Application Number: S6/2012/1142/FP

Comment: Re: planning application for 9, Wilkins Green Lane, AL10 9RT Reference S6/2012/1142/FP

TITLE  
 PROPOSED  
 GROUND FLOOR PLAN

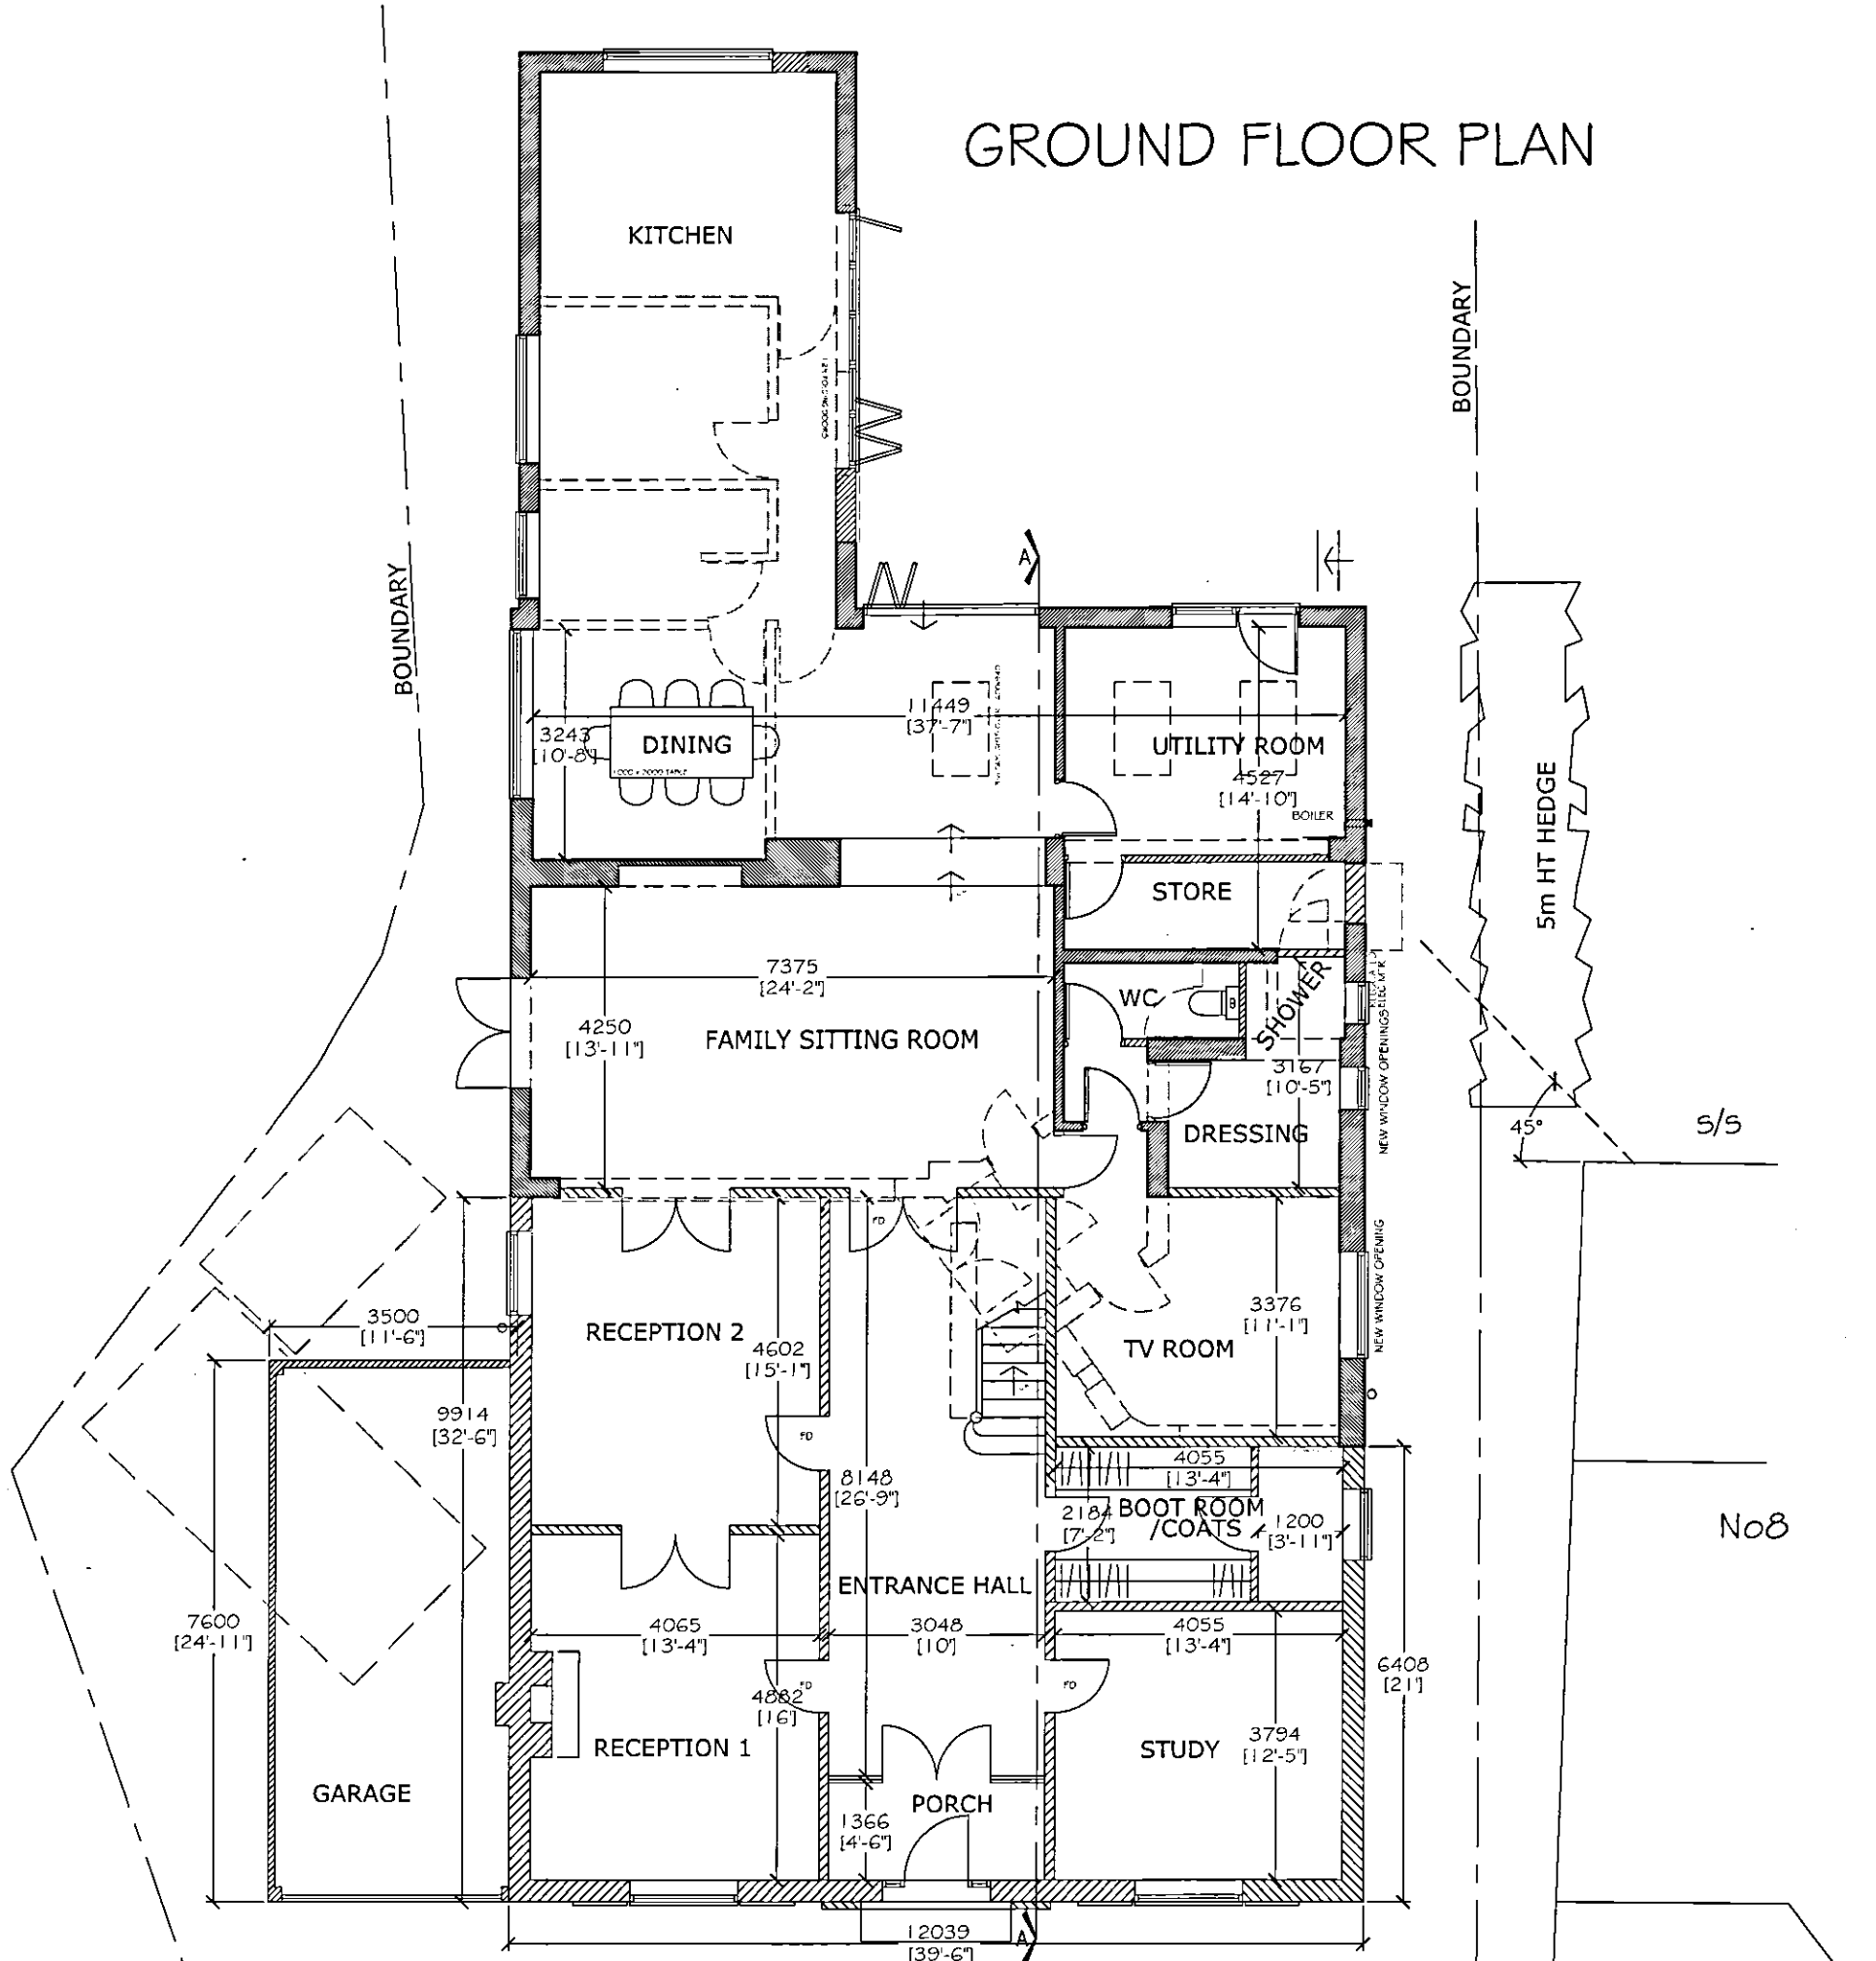
• The proposed building is far too large. It is clear from the block plan that the proposed footprint is approximately twice the size of neighbouring properties. Although there are larger houses in the road, they are all on much wider plots and so are further from their neighbours.

• The excessive depth of the building (from front to back) would make it appear over-bearing and too dominant.

TITLE
PROPOSED
REAR & SIDE ELEVATIONS

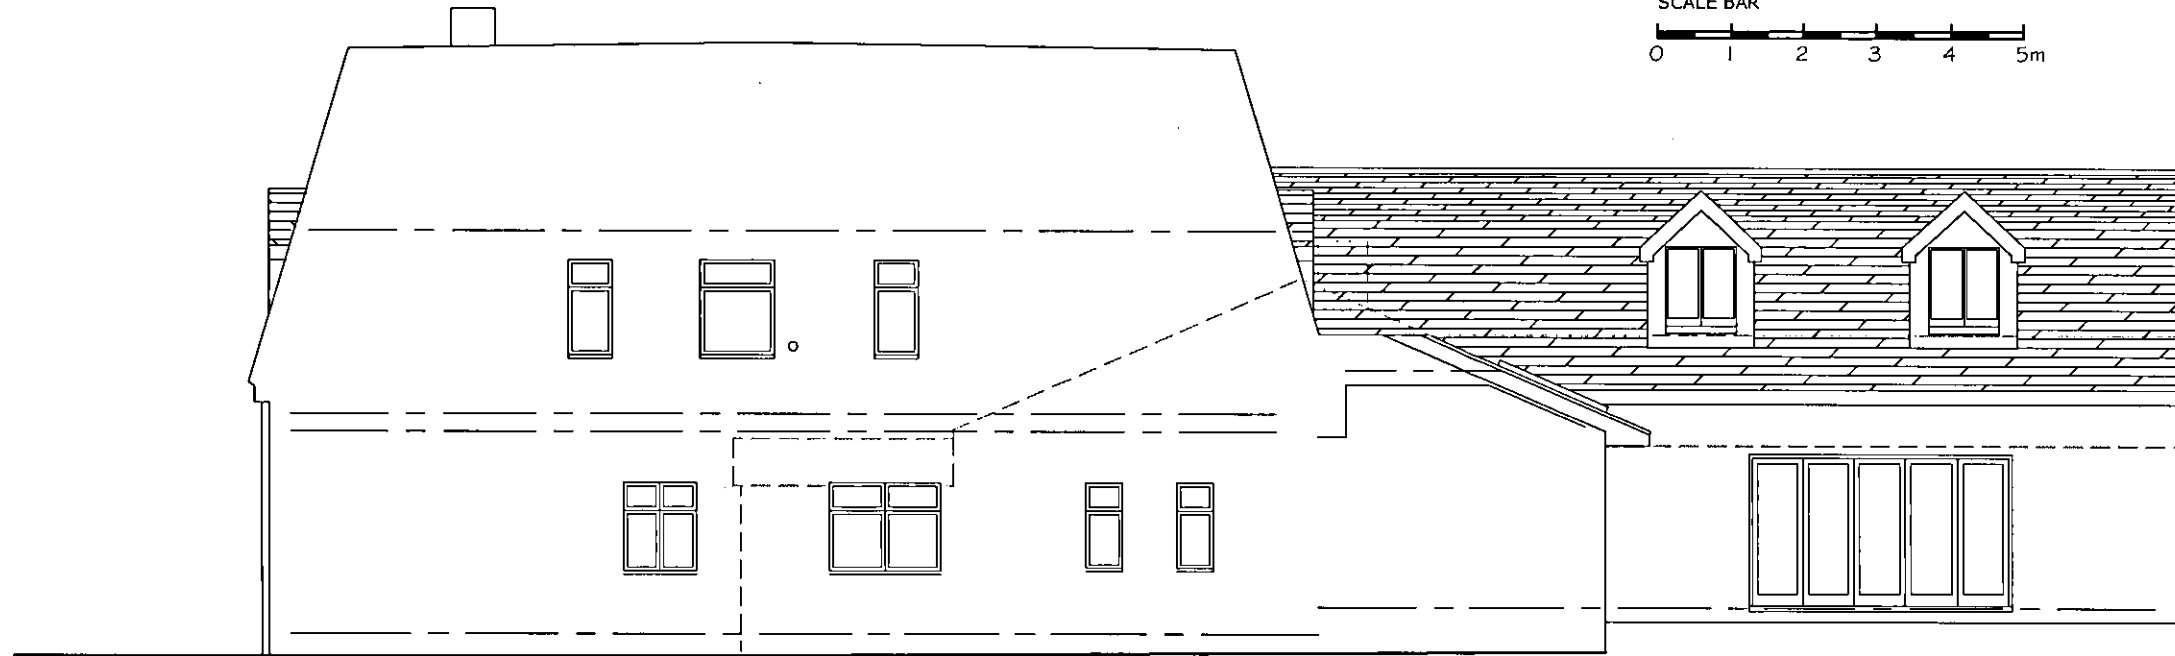
• The building is positioned to the SW of us, adjacent to our garden. An increase in height would cut off much of the remaining light from our garden, which is north-facing.

• There would also be a significant loss of privacy, as windows on the side elevation would overlook our garden.
